Appeal Decision

Appeal Ref: APP/R4408/W/17/3170209

Phase 2 development off Barnburgh Lane, Goldthorpe, Rotherham S63 9FB

- The application sought planning permission for the erection of 61 dwellings with garages and/or parking spaces together with the provision of open space and associated roads and sewers without complying with a condition attached to planning permission Ref: 2015/1198, dated 30 June 2016.

title Garage Threshold / Gravel Drive Details

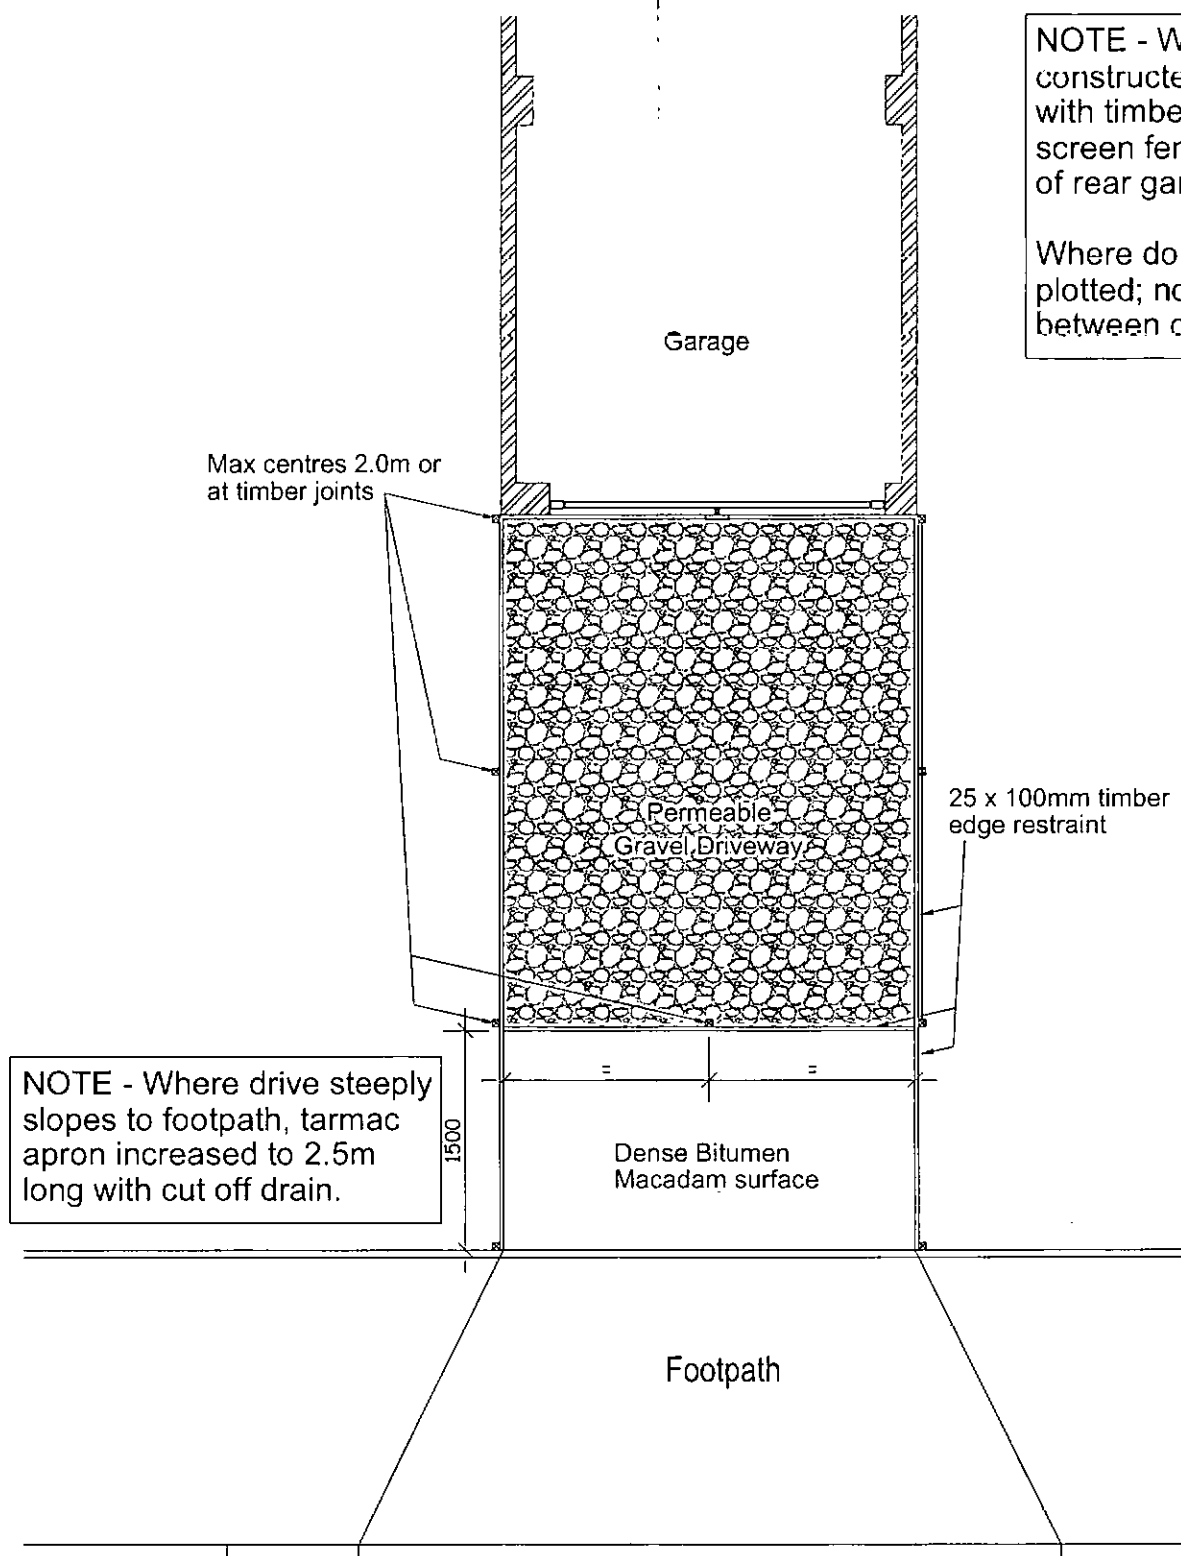
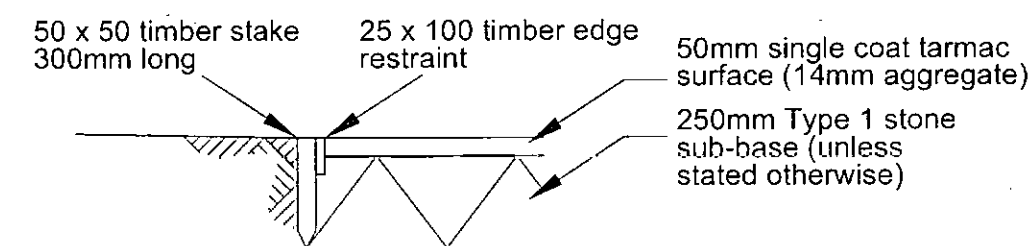
10. The appellant states the proposed specification of the driveways comprises of no more than two layers of aggregate and that the upper layer locks into the lower to create a durable surface. Whilst this may be the case when initially laid, I note that the appellant accepts that small amounts of aggregate may be tracked onto the highway. It seems to me that if aggregate can be displaced from the driveway, as accepted by the appellant and was evident when I visited the site, this is indicative that the lock between the layers of aggregate is not entirely secure and that if some stones are dislodged it becomes compromised. In my view, this would be exacerbated if the driveway were regularly raked as advised in the Home Owner's Manual produced by the appellant for purchasers of their houses, as this would further disturb any bond between the aggregate pieces. This being the case, aggregate migrating onto the highway and footways is likely to continue.

27. The Council suggest that the driveway specification does not meet the National House Building Council (NHBC) standard. Table 2d in the NHBC standard is referred to and in this table the construction details for each road type are determined by reading down the relevant column. For a gravel road there is no requirement for a bound surface and footnote 7 to the table states that the requirement for the wearing course is a 38mm thickness of 15/20mm unbound aggregate, well rolled and compacted. This is what is specified in the appellant's drawing. Nevertheless, the NHBC standards do not override any local requirements.
